Revise to
"DISTRICT 49 ELEMENTARY
EXEMPTION PLAT"

LAND SURVEY PLAT

LAND SURVEY PLAT
JOB NO. 70-034A
DATE PREPARED: 21 APRIL 2017
DATE REVISED:

LAND SURVEY PLAT  
 JOB NO. 70-034A  
 DATE PREPARED: 21 APRIL 2017  
 DATE REVISED: 08 JUNE 2017  
 PCD FILE NO. EX-17-001

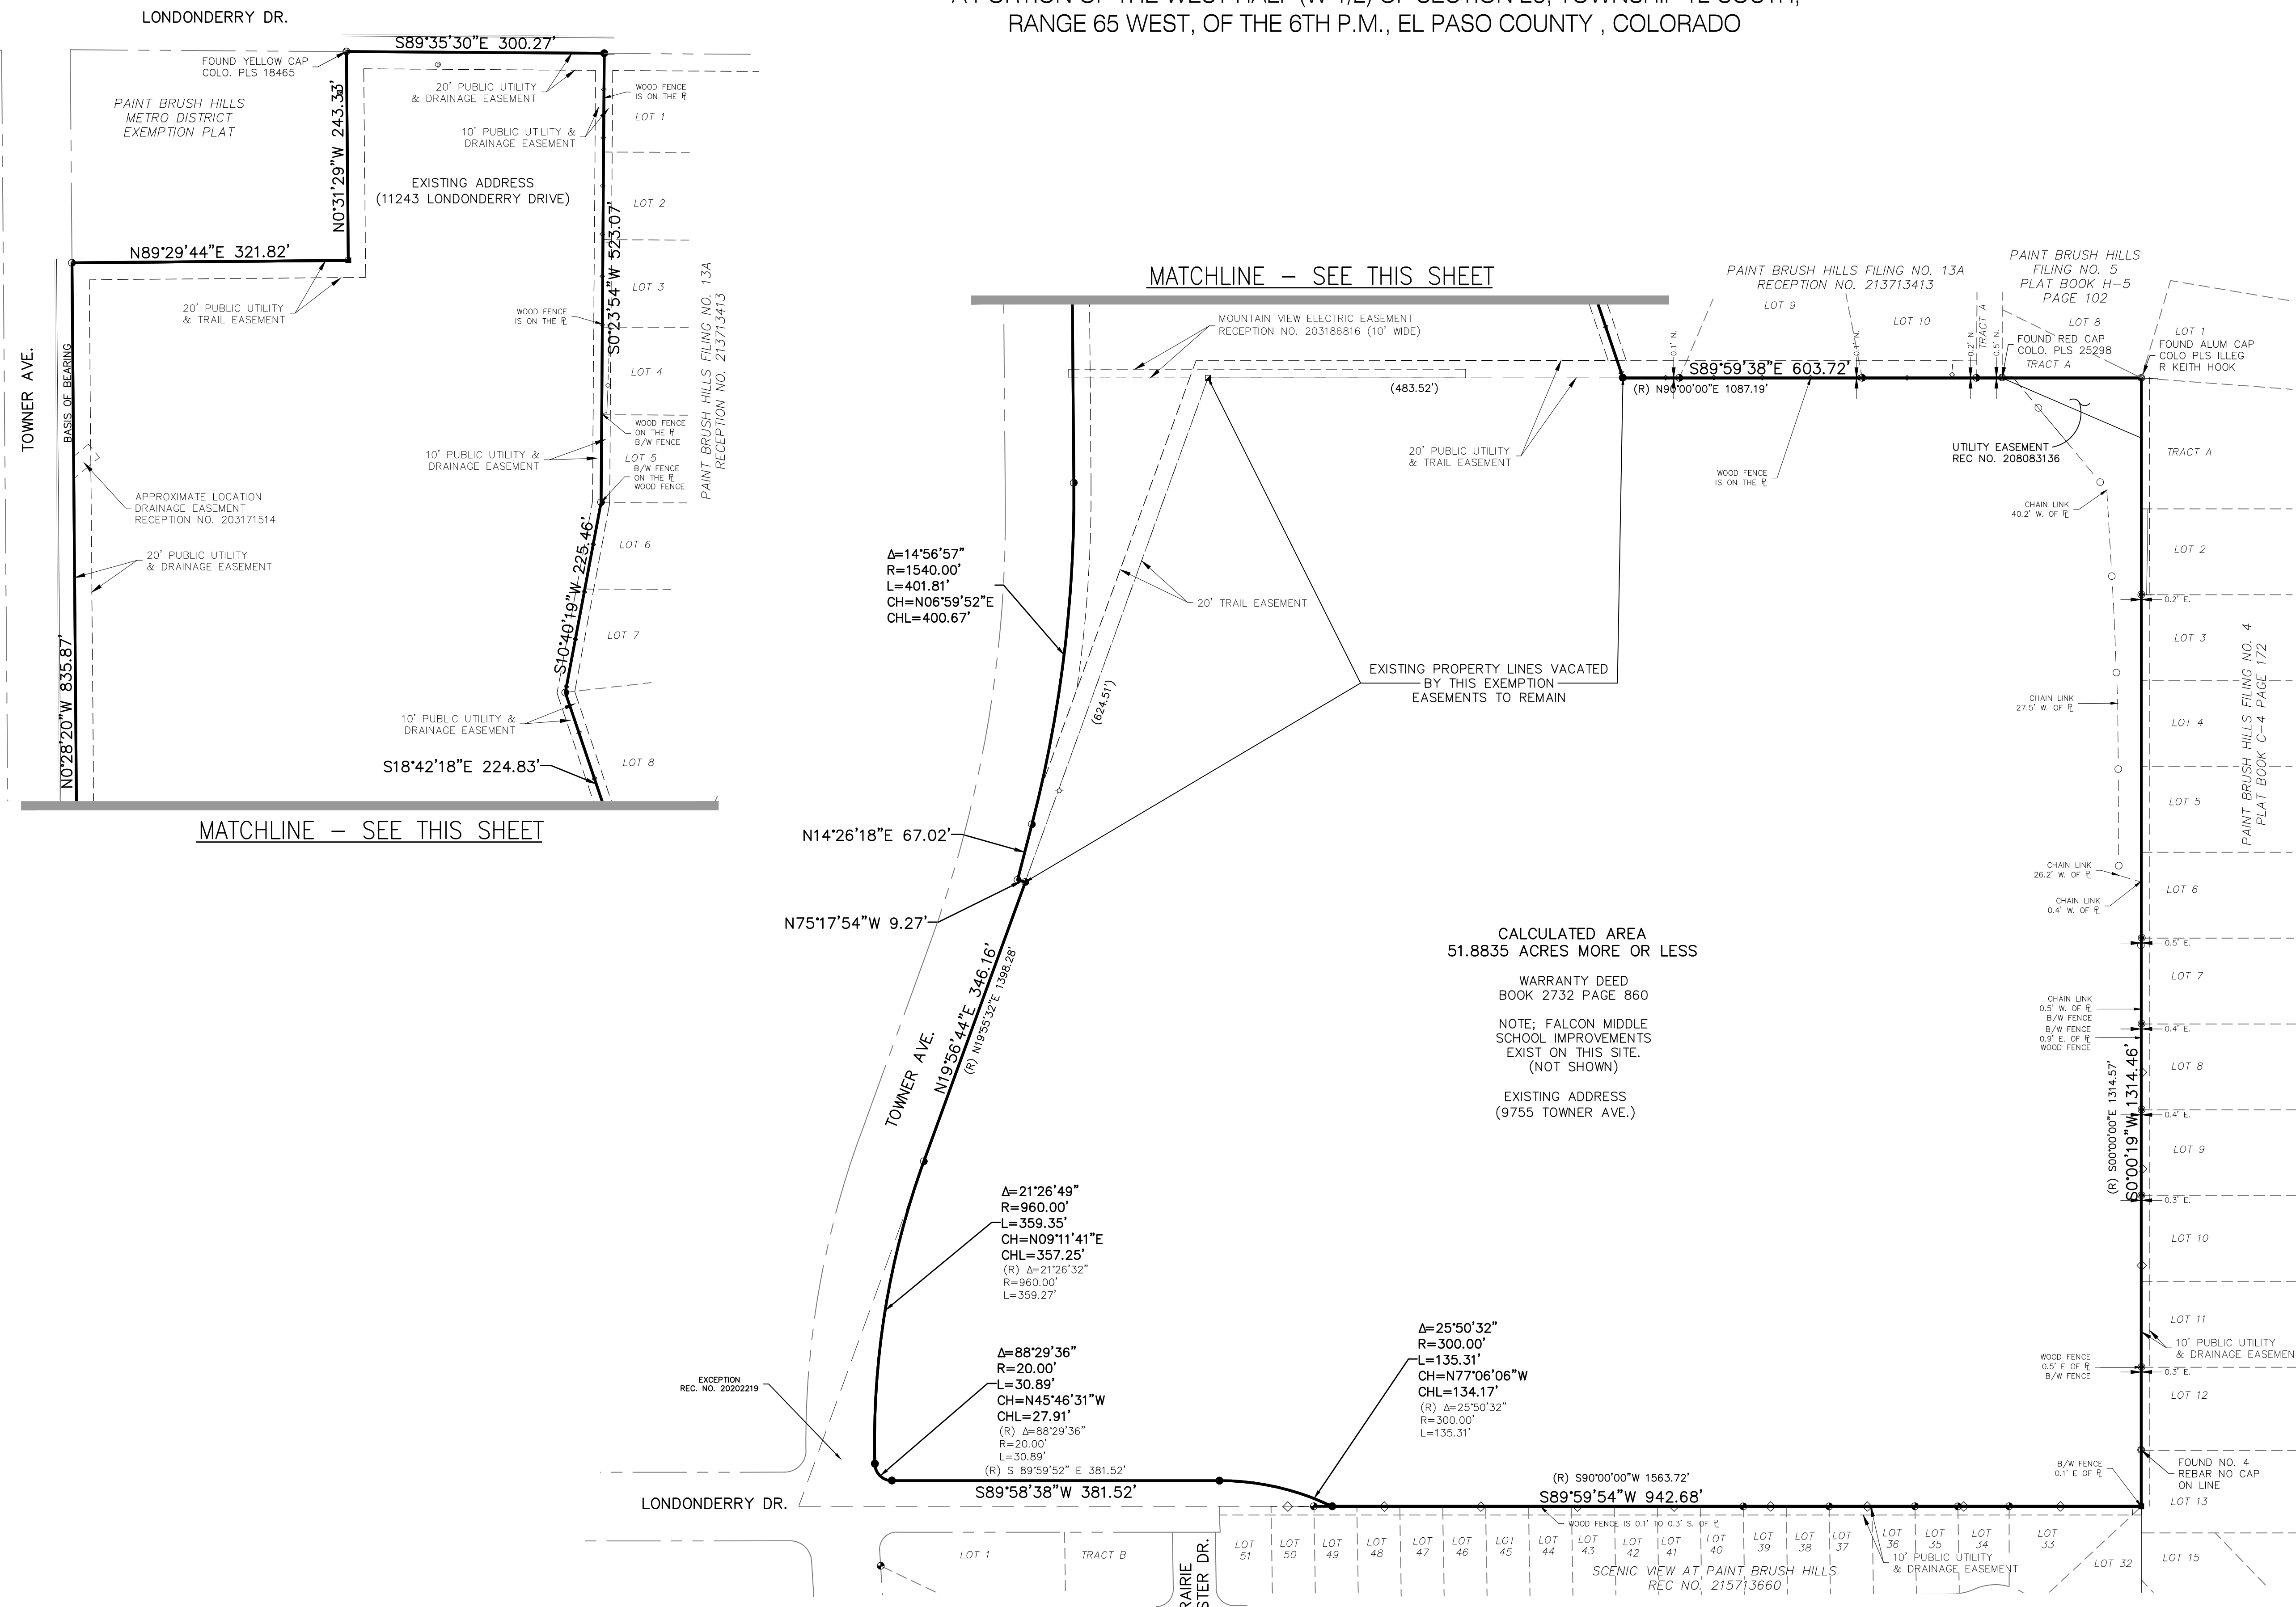
Add: "PCD File No. EX-17-001"
